Our ref: TR010064/Deadline 5

### **TR010064 - M60/M62/M66 Simister Island Interchange EXAMINATION DEADLINE 5 SUBMISSIONS**

FIGURE 2.3

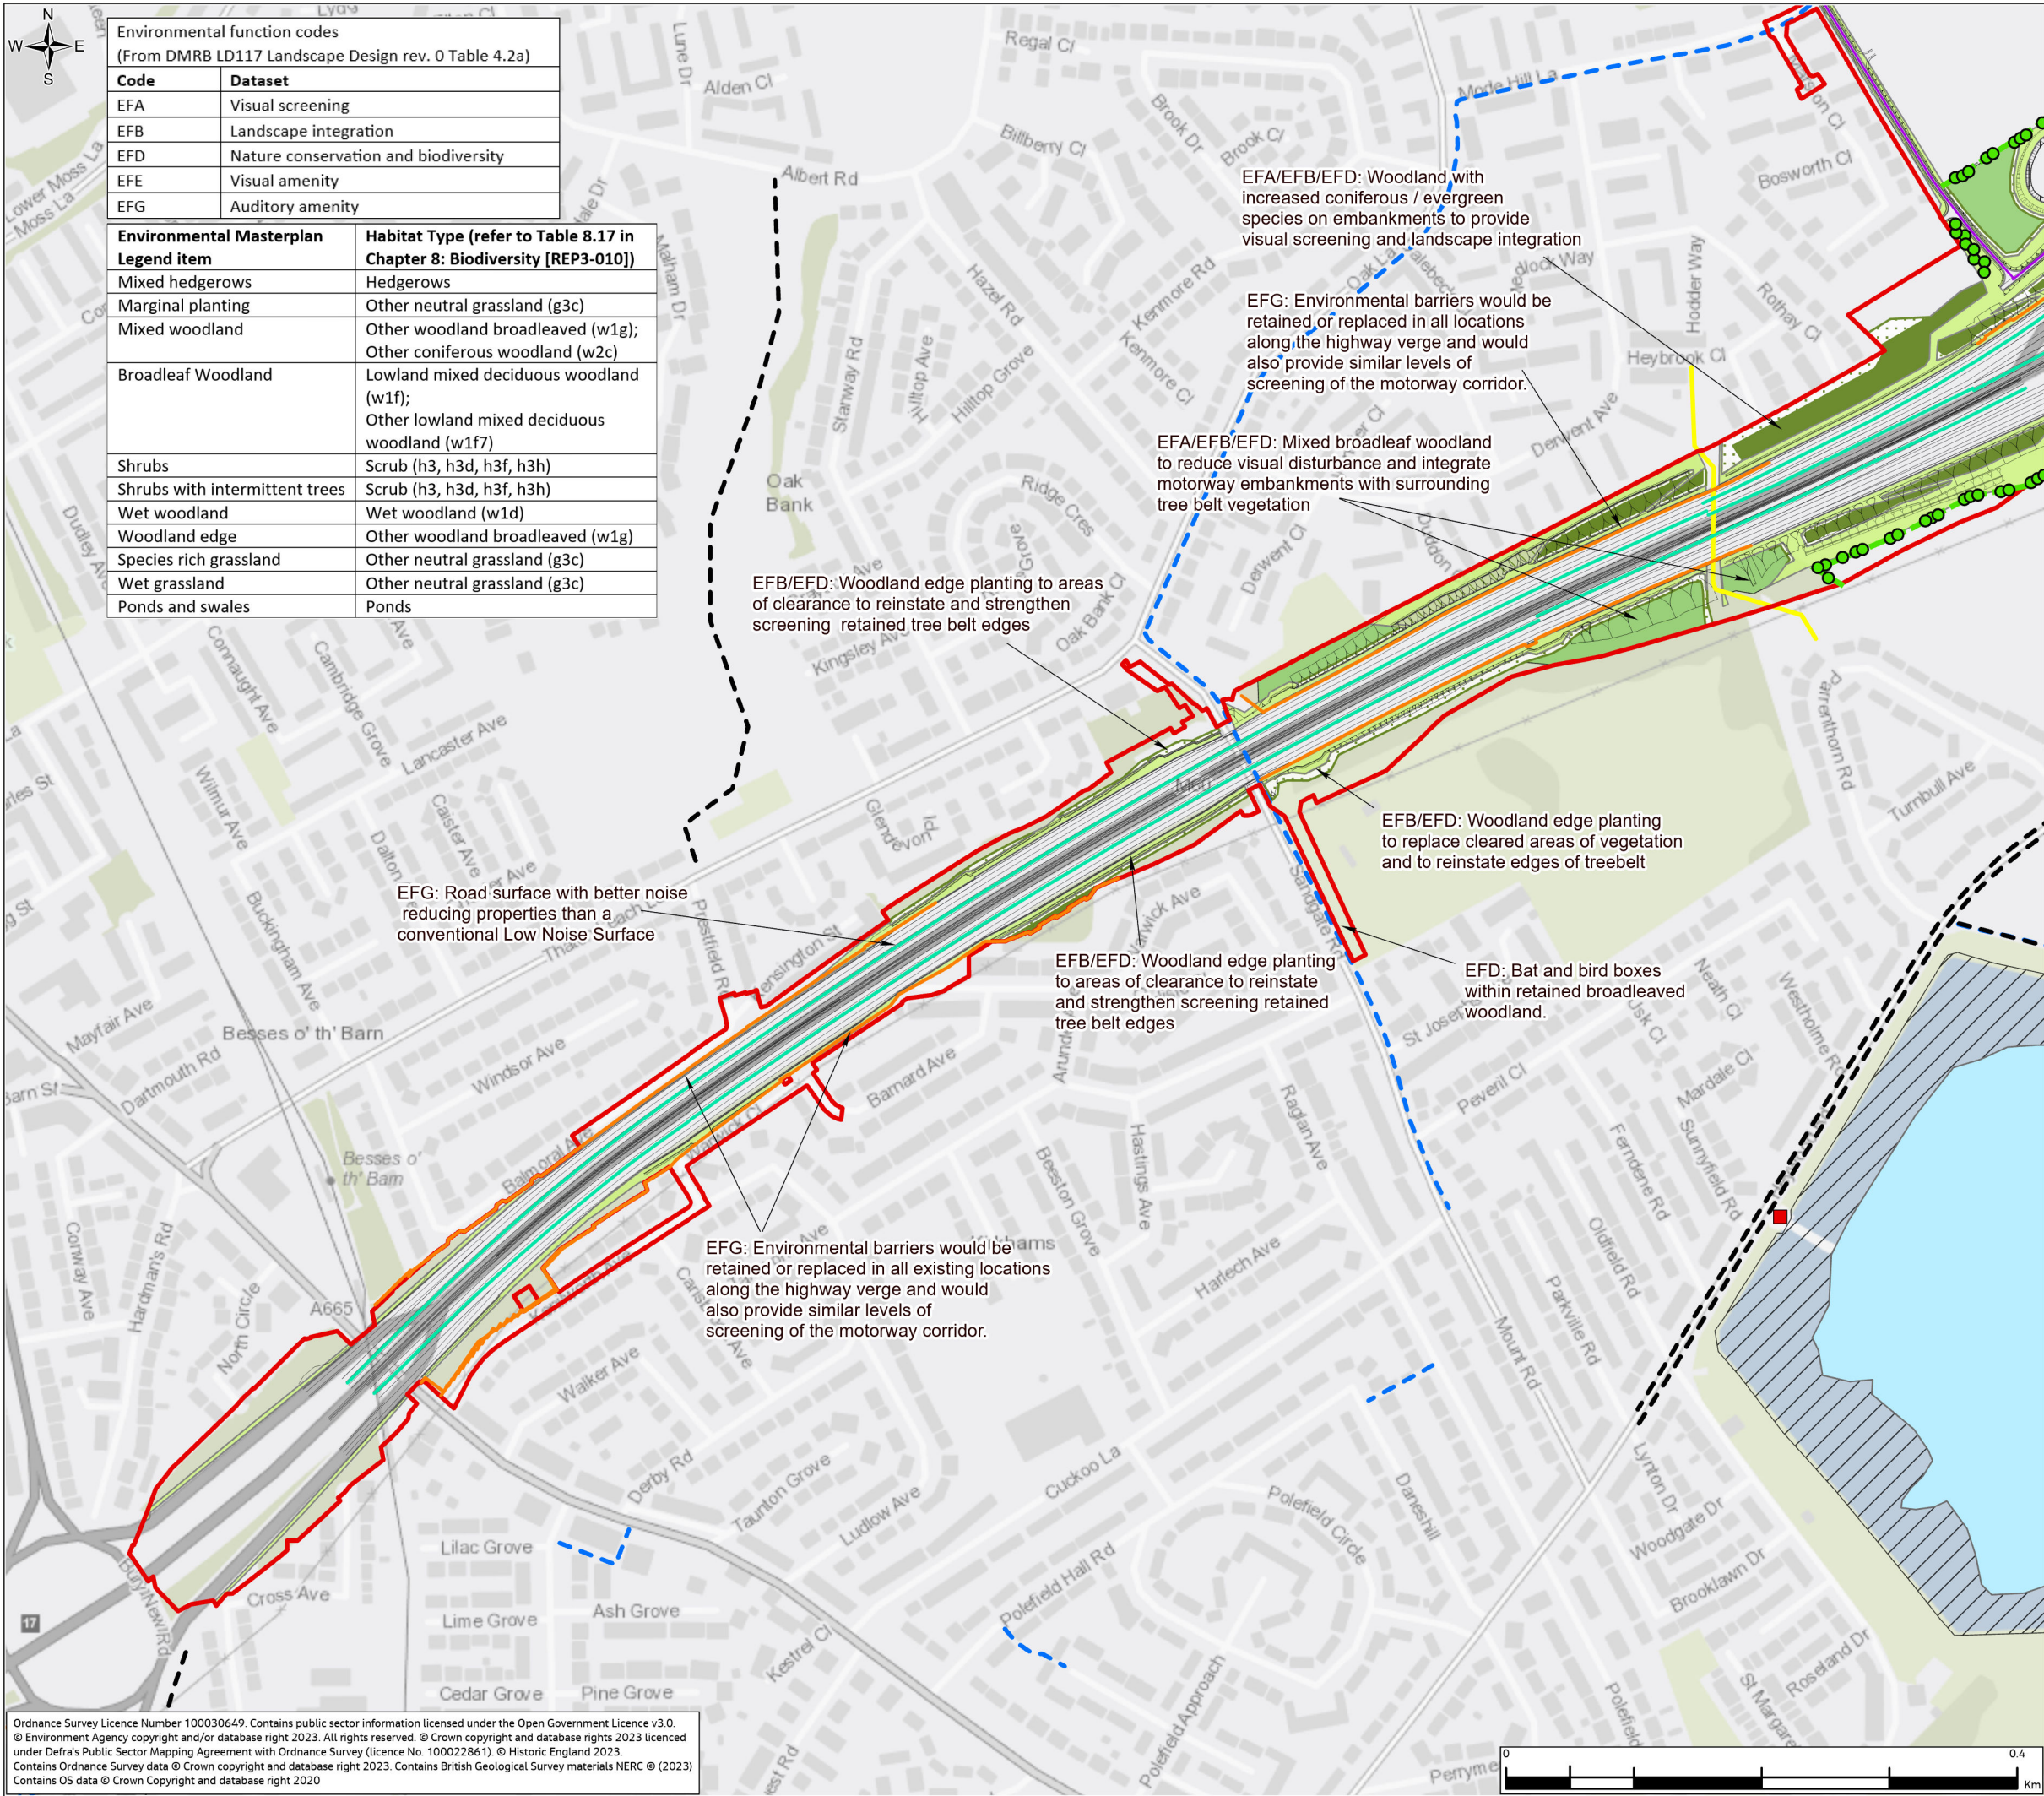
In responding to ExQ2 BIO.2.2 relating to Habitat Loss and Habitat Gain the Applicant has reviewed Figure 2.3 Environmental Masterplan of the Environmental Statement Figures [APP-057]. To assist with the interpretation of the Environmental Masterplan a table has been inserted to clarify which habitat type relates to which landscape description.

In undertaking this review the Applicant identified that the extent of the noise barriers and that of Public Right of Way 9WHI was not fully in alignment with the existing and so has been amended to the correct extent.
